Planning authority	Kildare County Council
Planning authority register reference number	25/61119
Address of proposed development	Lands At Railpark Railpark Maynooth Kildare Ireland

Re: Appeal Submission Regarding Proposed Development Adjacent to Rockfield, Railpark, Maynooth

Planning Reference No: 25/61119

Figure 3.1: Western Boundary Treatment Drawing

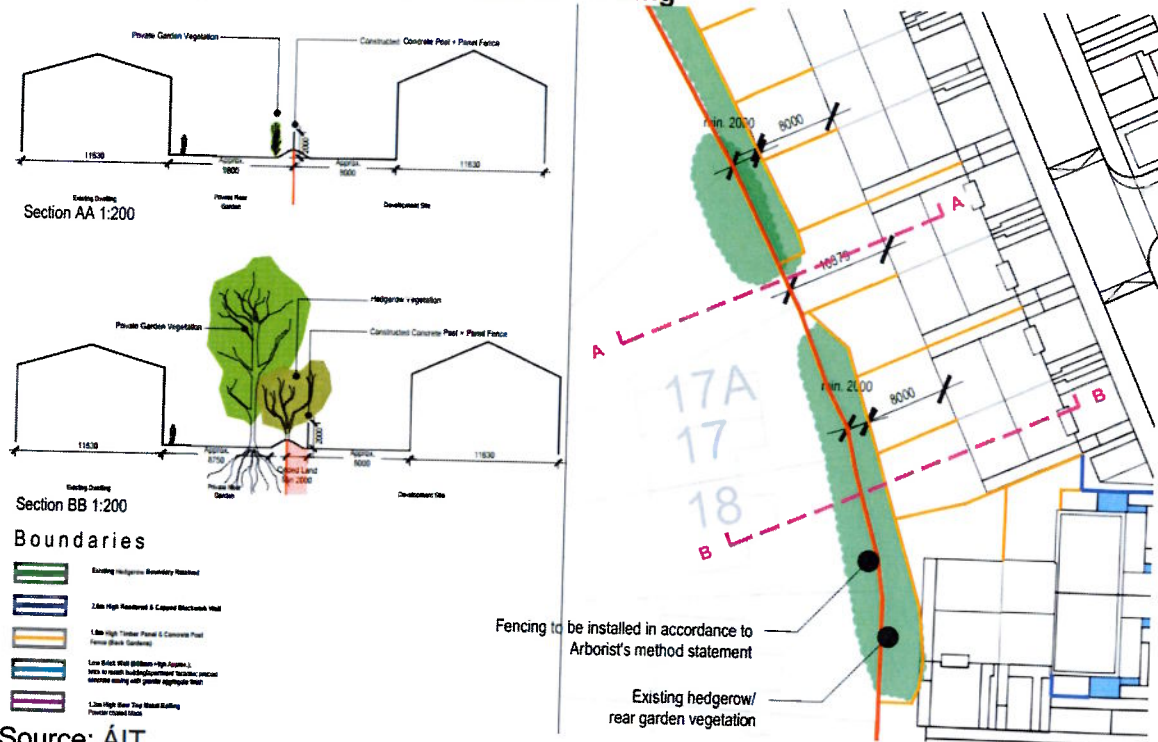
The proposed boundary treatment between the existing estate and the new development consists of a weld mesh/Hercules-type fence rather than a solid wall structure. This form of boundary is wholly unsuitable in a residential setting where existing family homes directly adjoin the development at 18 (a) (iv) in planning approval by KCC.

The proposed fencing arrangement creates serious privacy concerns due to visual intrusion between the existing and proposed dwellings. Where the rear garden is considered the curtilage of the family home, a see-through fence does not offer the same protection as a block wall to the family and in particular the protection and privacy of children.

A solid boundary wall of appropriate height and finish consistent with all new developments in Maynooth where there are adjoining gardens should instead be required in order to:

Figure 3.7: Extract of Layout illustrating 'cul de sac'

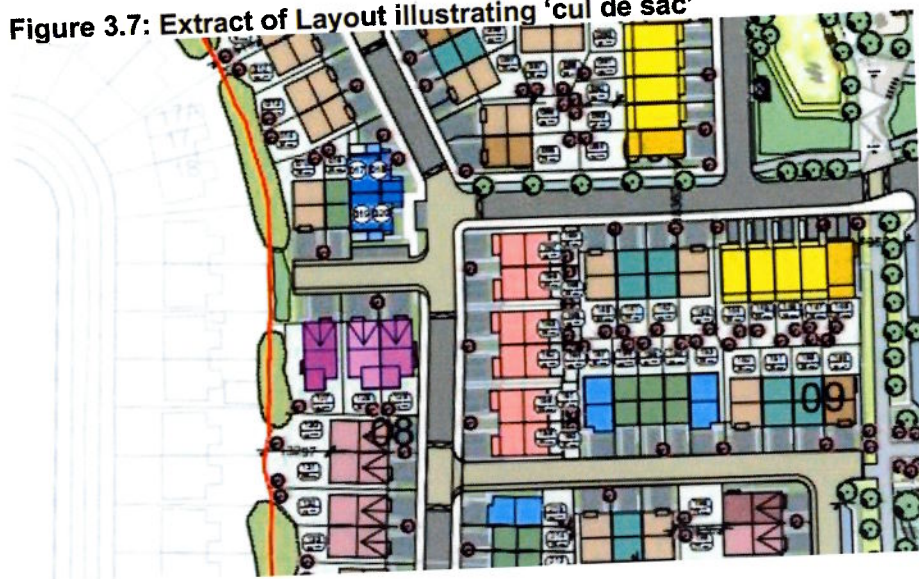
The proposed cul-de-sac arrangement located directly behind existing properties gives rise to substantial concerns regarding privacy and residential security.

The positioning of a roadway and turning area to the rear of existing gardens creates an unnecessary opportunity for overlooking, loitering, noise disturbance, and unauthorised access to adjoining homes. The layout is inconsistent with good residential design principles and does not adequately protect the established amenity of current residents.
